# Planning and Urban Development Department

**Subject:** B-2c Design Review – 72 Bishop Street  
**Written by:** Caitlin Cameron, Urban Designer  
**Date of Review:** Wednesday, April 29, 2015

Drawing file: Advance site work_cutting / 151228 Bishop Street - L2 layout and lighting plan.pdf

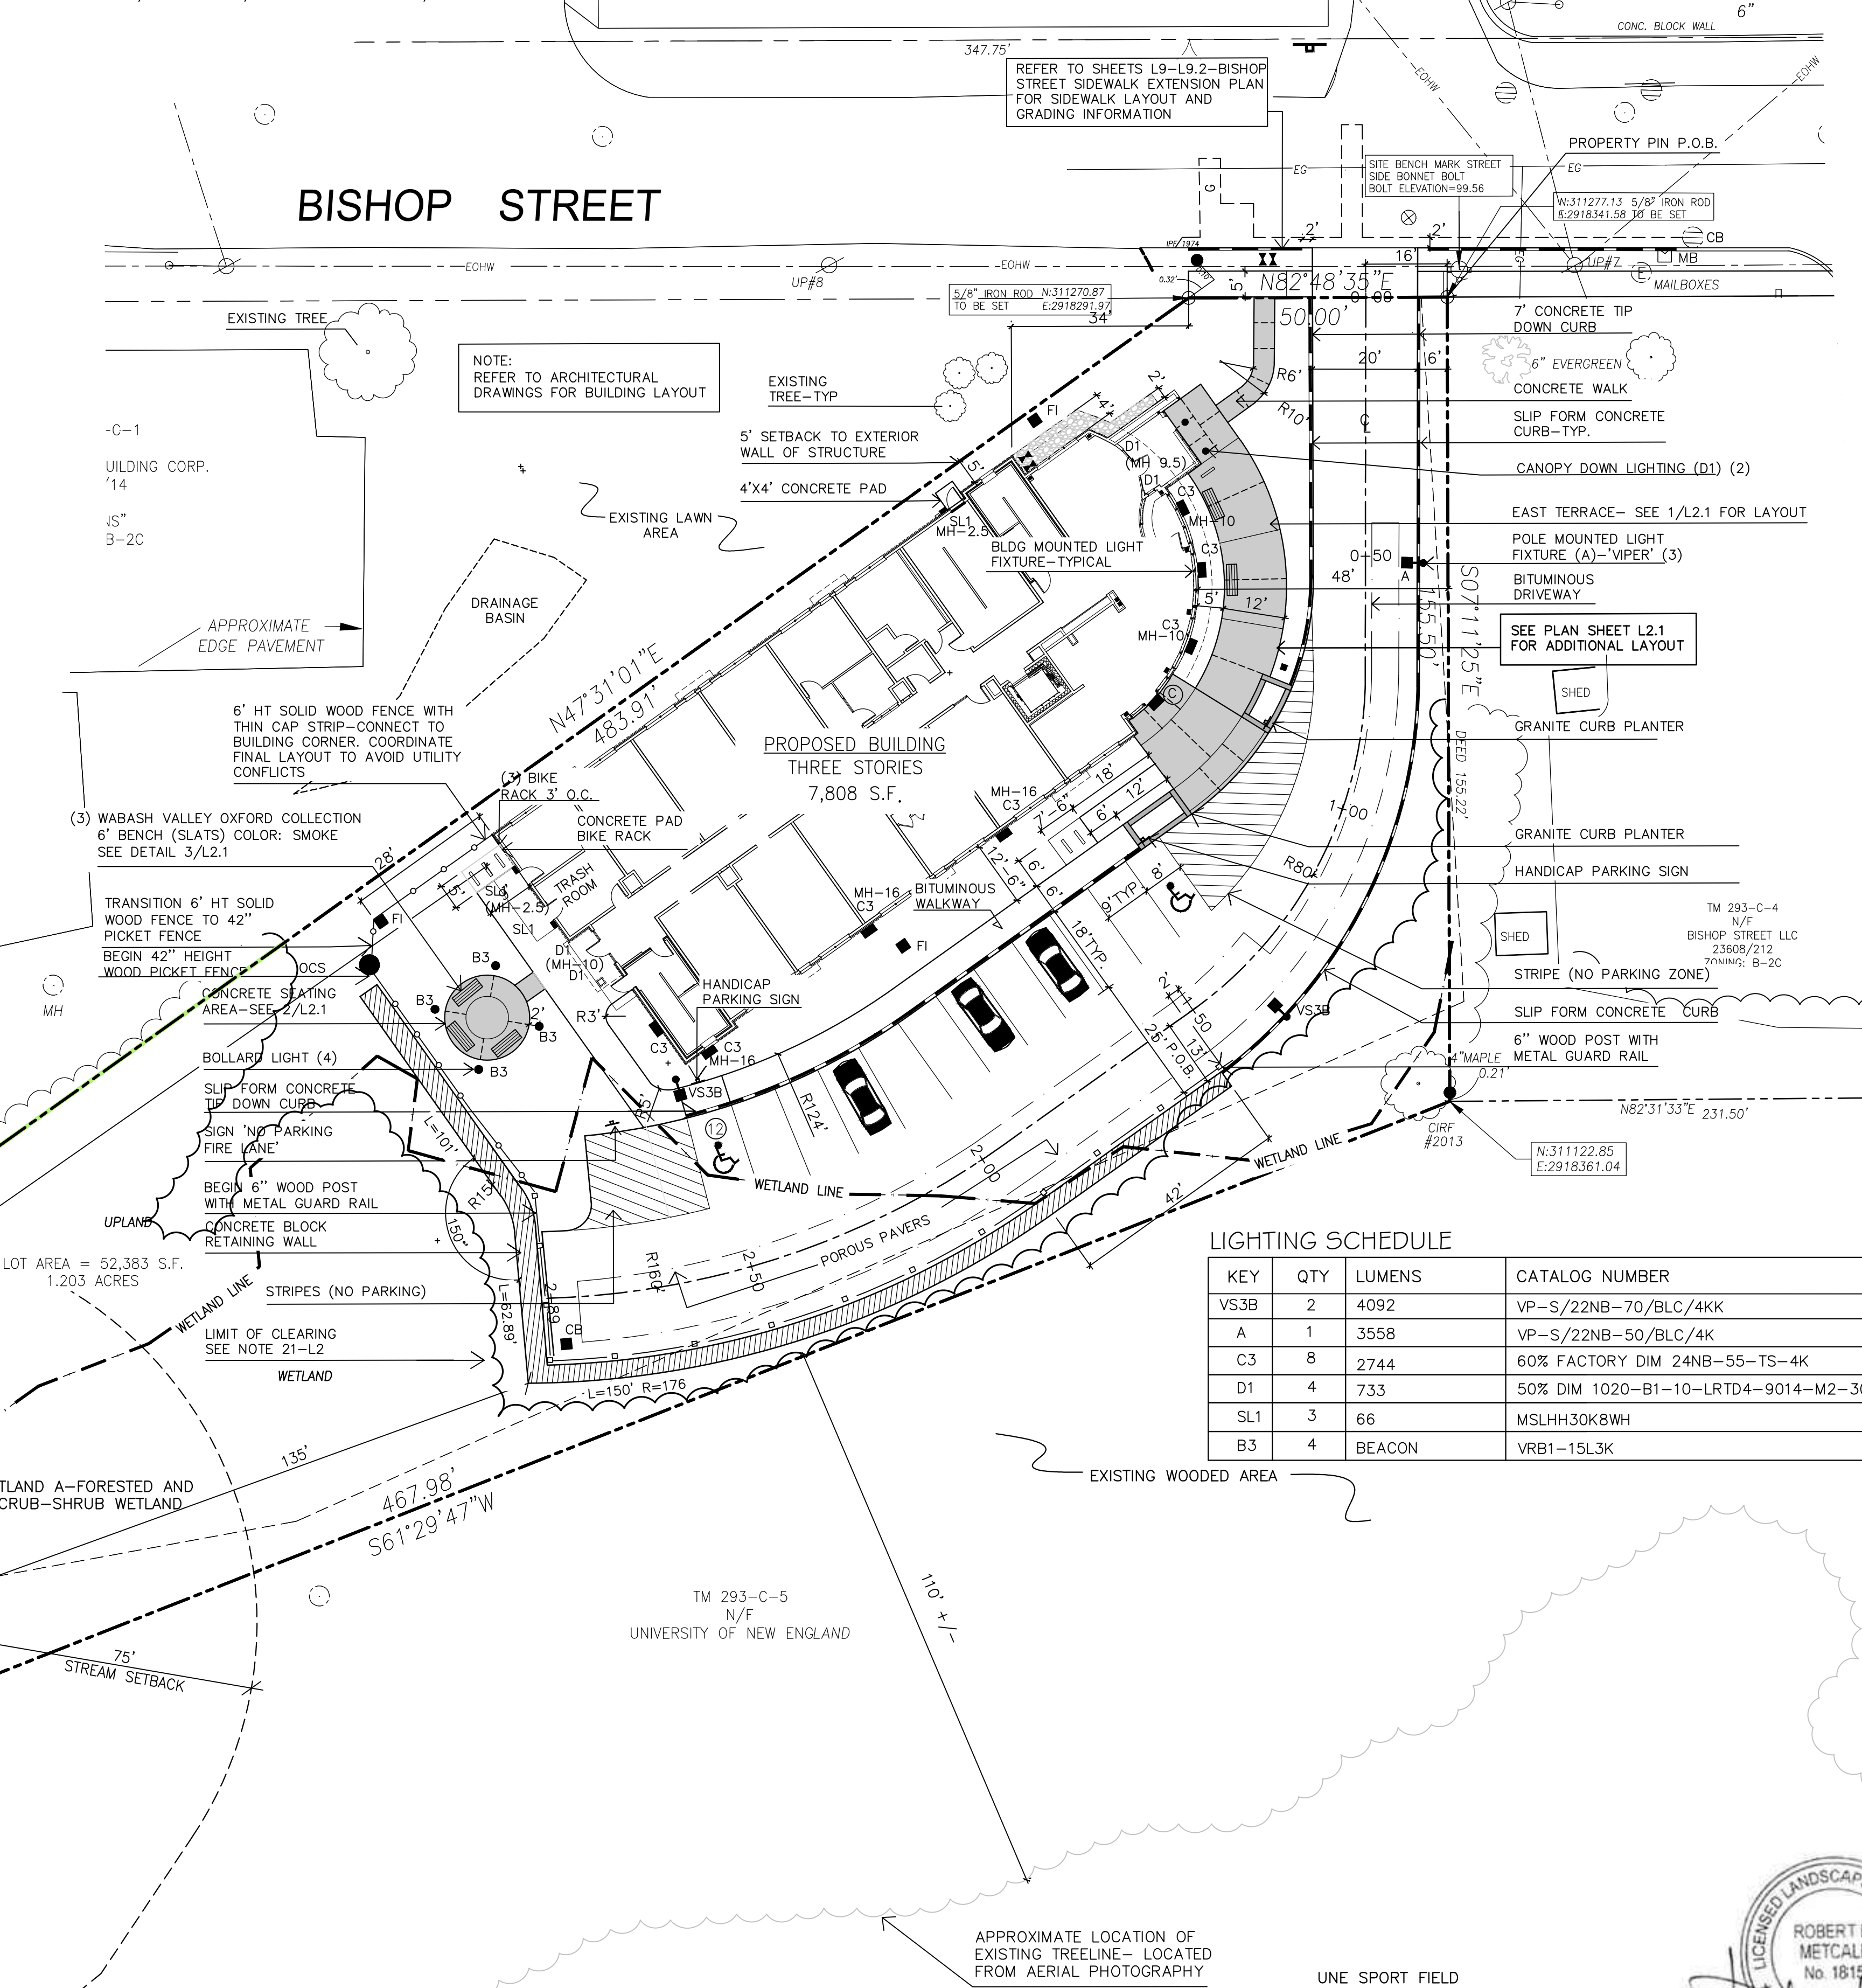
*Standard 5* – Parking is well screened and positioned away from the street. **However, more detail is requested regarding the height and material of fences around the property – visual and sound screening is desirable between the parking and neighboring property as well as between the outdoor seating area and neighboring property. What will be the landscape treatment at the Northeast face of the building?**
